Your Ref: 100646933-001
Our Ref: 23/02791/FULL

Date 23rd October 2023

Application No: 23/02791/FULL
Proposal: Change of use of ancillary annexe to short term let
(retrospective)
Address: New Lulgate Lucklawhill Balmullo St Andrews Fife

Drawing
 sketch plan & section

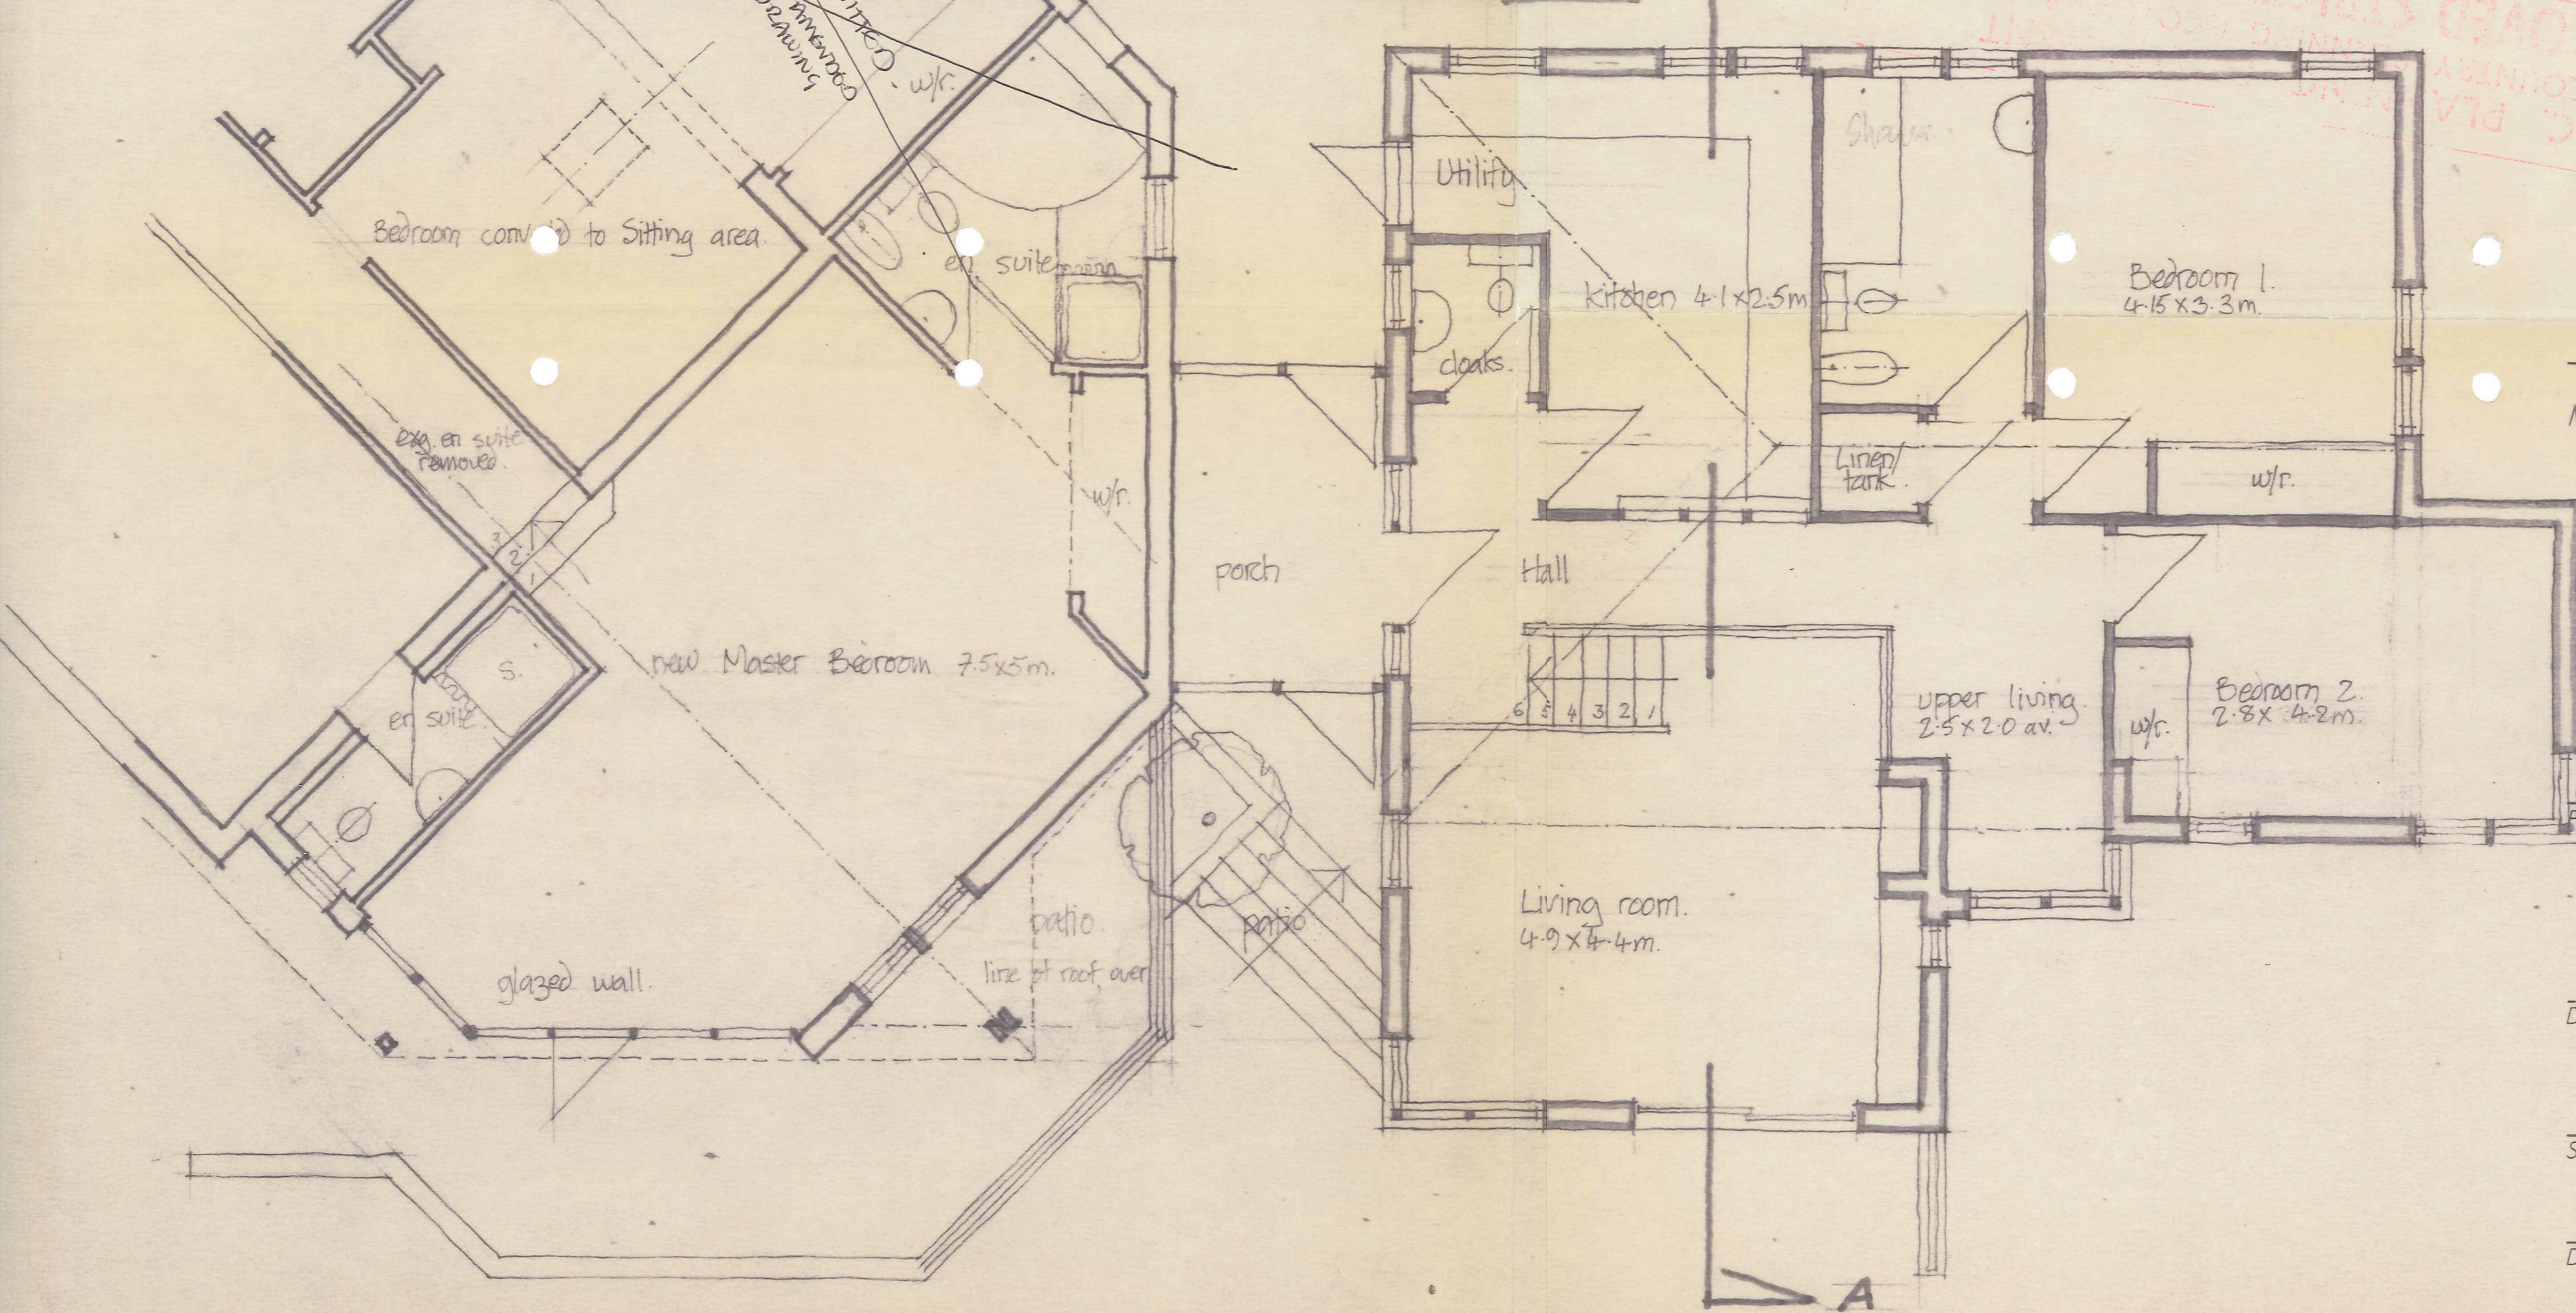
1. It is appreciated that the floor plan has been taken from the 1991 application, however it does not meet present day validation standards. In this case would you be able to provide a scale bar to the drawing, which reflect the annotated scale to the title box. In addition to this it is not clear from the drawings, which part of the building is subject to the change of use proposal. Please provide further drawing annotation to show the area of retrospective use.

2. Once the drawing has been amended a further assessment shall be made for the fee based on the indicated floor area.
3. Please provide a Block Plan of the site, that clearly shows the existing parking arrangements for the retrospective use. This block plan should be scaled at no less than 1:500.
